## **MEETING MINUTES**

**Subject:** NoDa Community Meeting, Charlotte, NC  
Bloc Design Project:

**Date of Meeting:** January 12, 2022

**Remarks:** Conference call to discuss project rezoning.

SHEET NO.: **RZ-1**

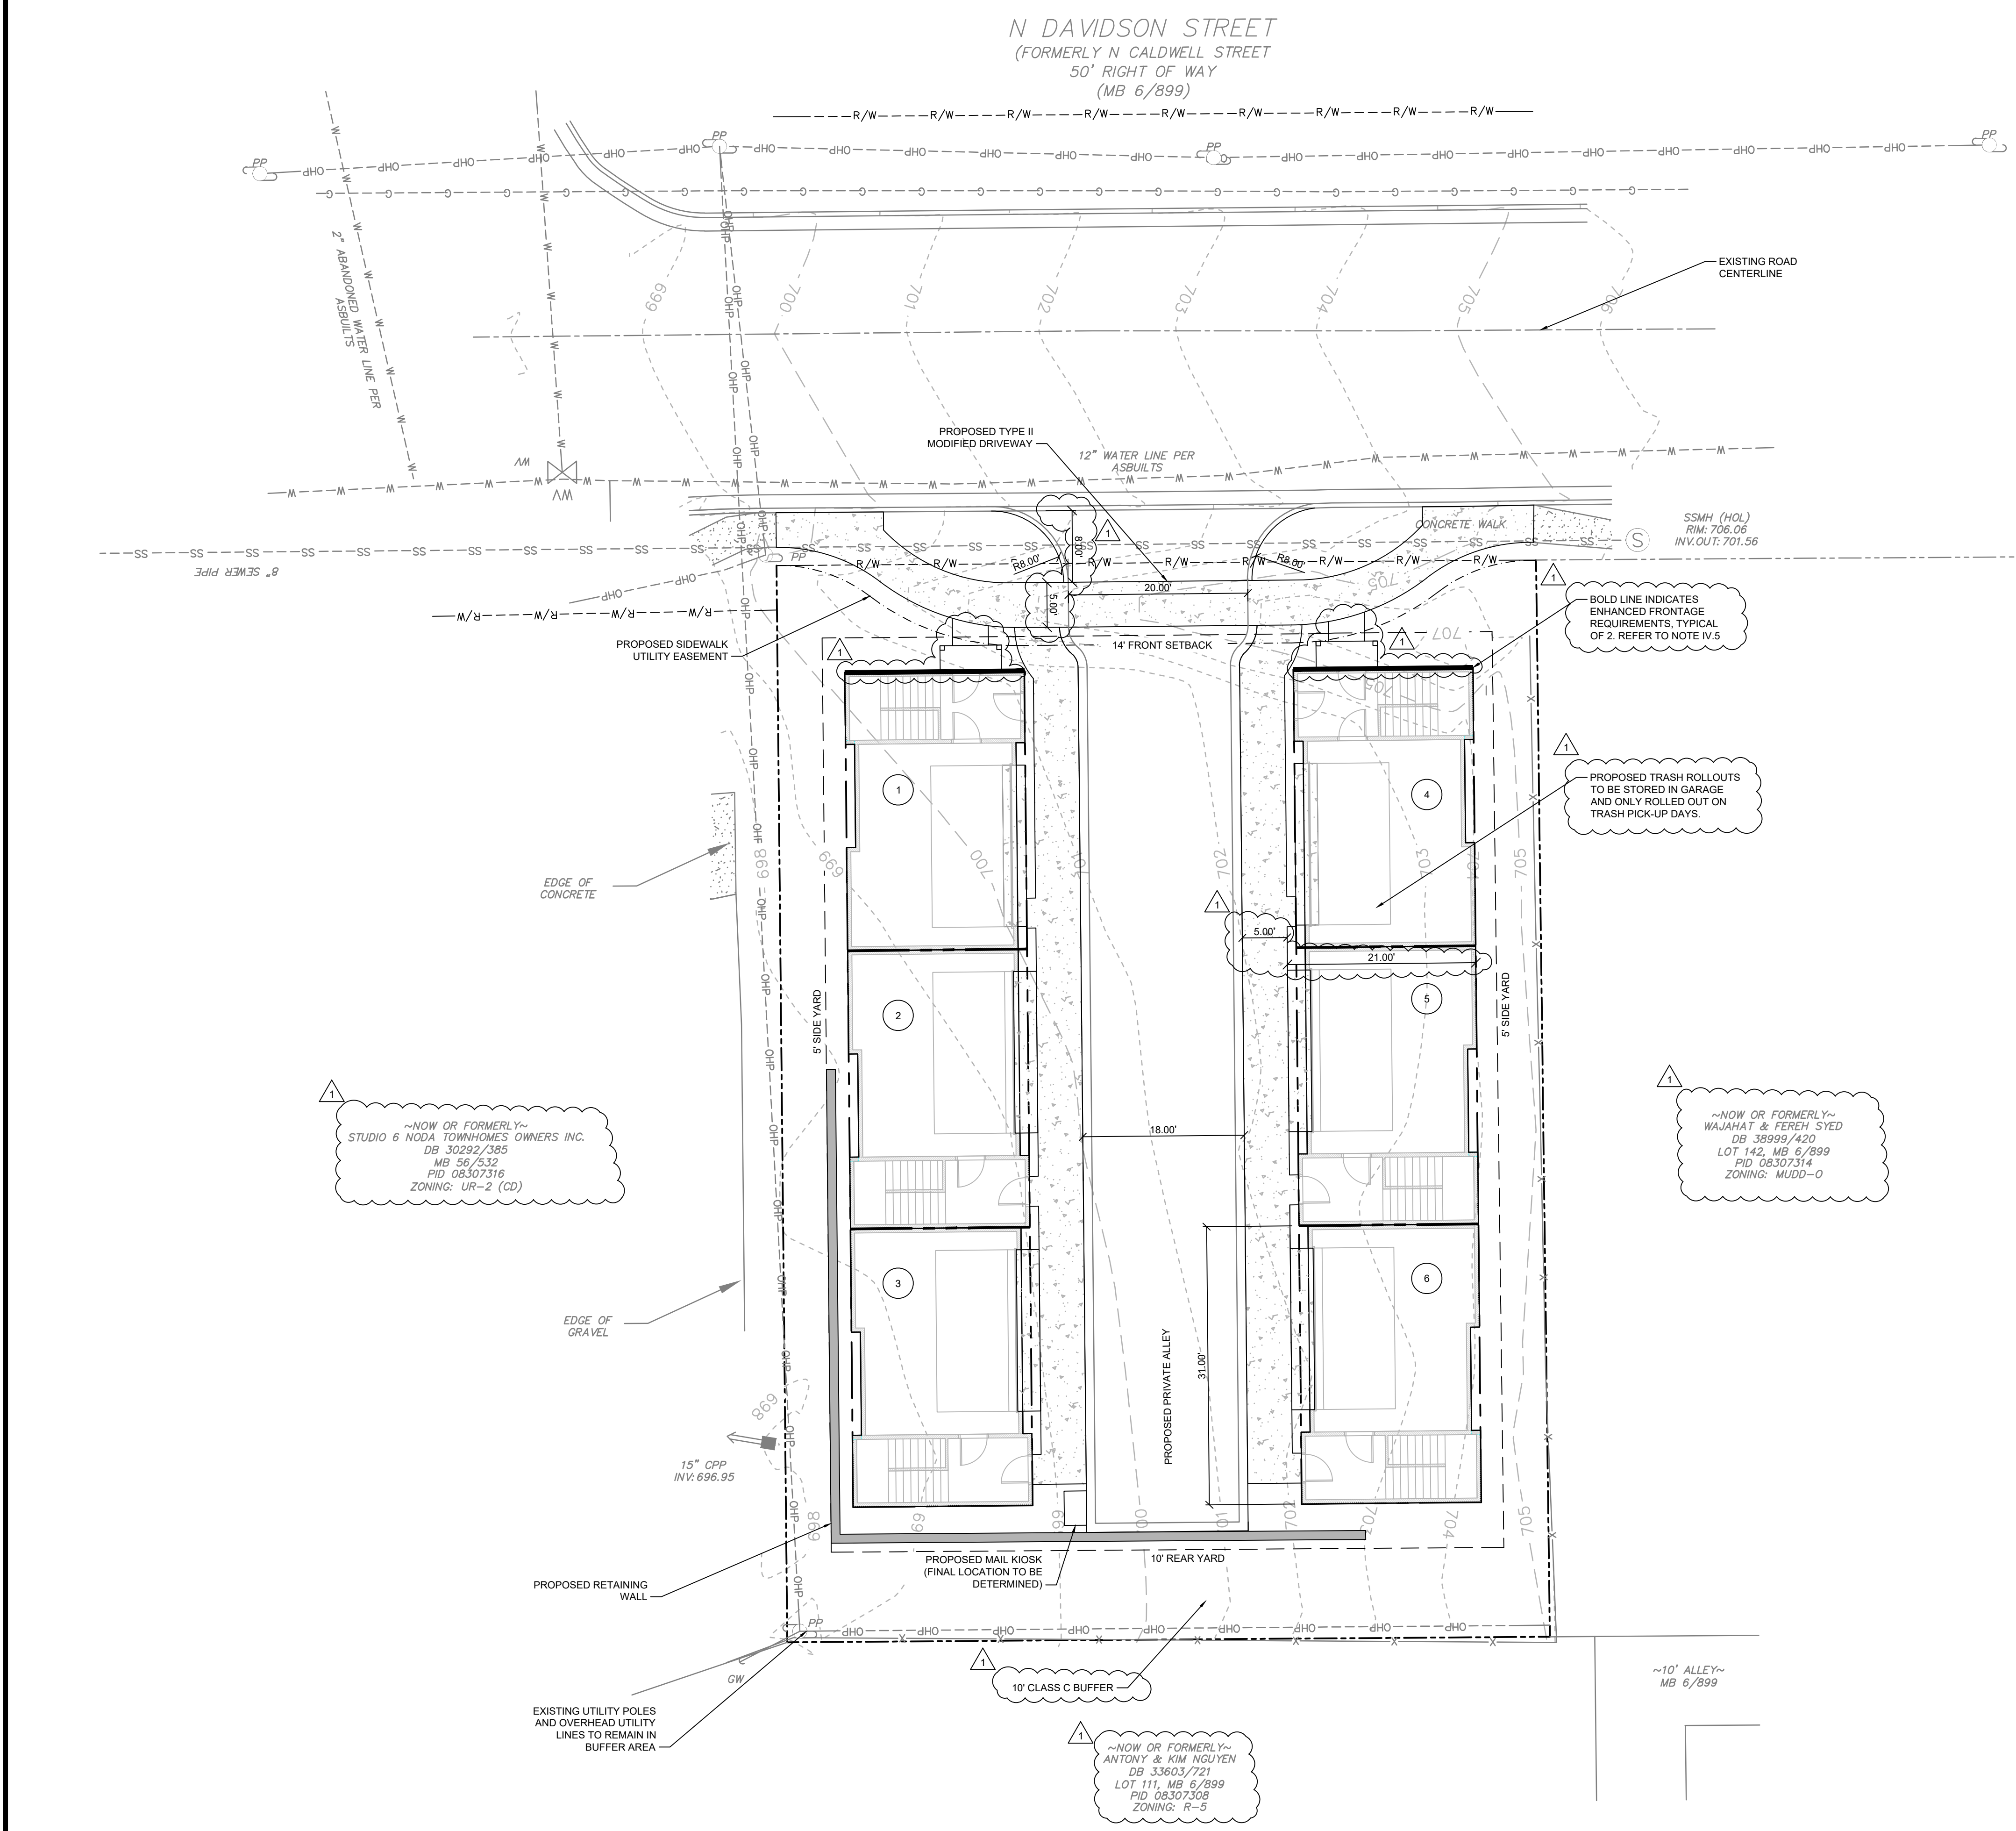
3. PM Mark Caspar – Provided an overview of the site location and approach.
4. Gray Stout-Provided an overview of the architectural approach and design
5. Chad Maupin: Would like a front porch on North Davidson to match the community. Perhaps a community porch. Also asked why not a single side loaded street.

- b. Eric discussed moving away from a singular feel. This design provides a community that works well to provide an elegant feel.
6. Chad Maupin: Can you adjust the sidewalk to meet the adjacent sidewalk to avoid an S-curve feel.

- a. Mark Caspar- Current sidewalk includes a planting strip. Will discuss options with City Staff in review meeting on January 13, 2022.
  - b. Eric Woods – Supports reconstructing sidewalk on adjacent property to provide a continuous sidewalk with a planting strip. Can approach adjacent property to make a more cohesive flow.
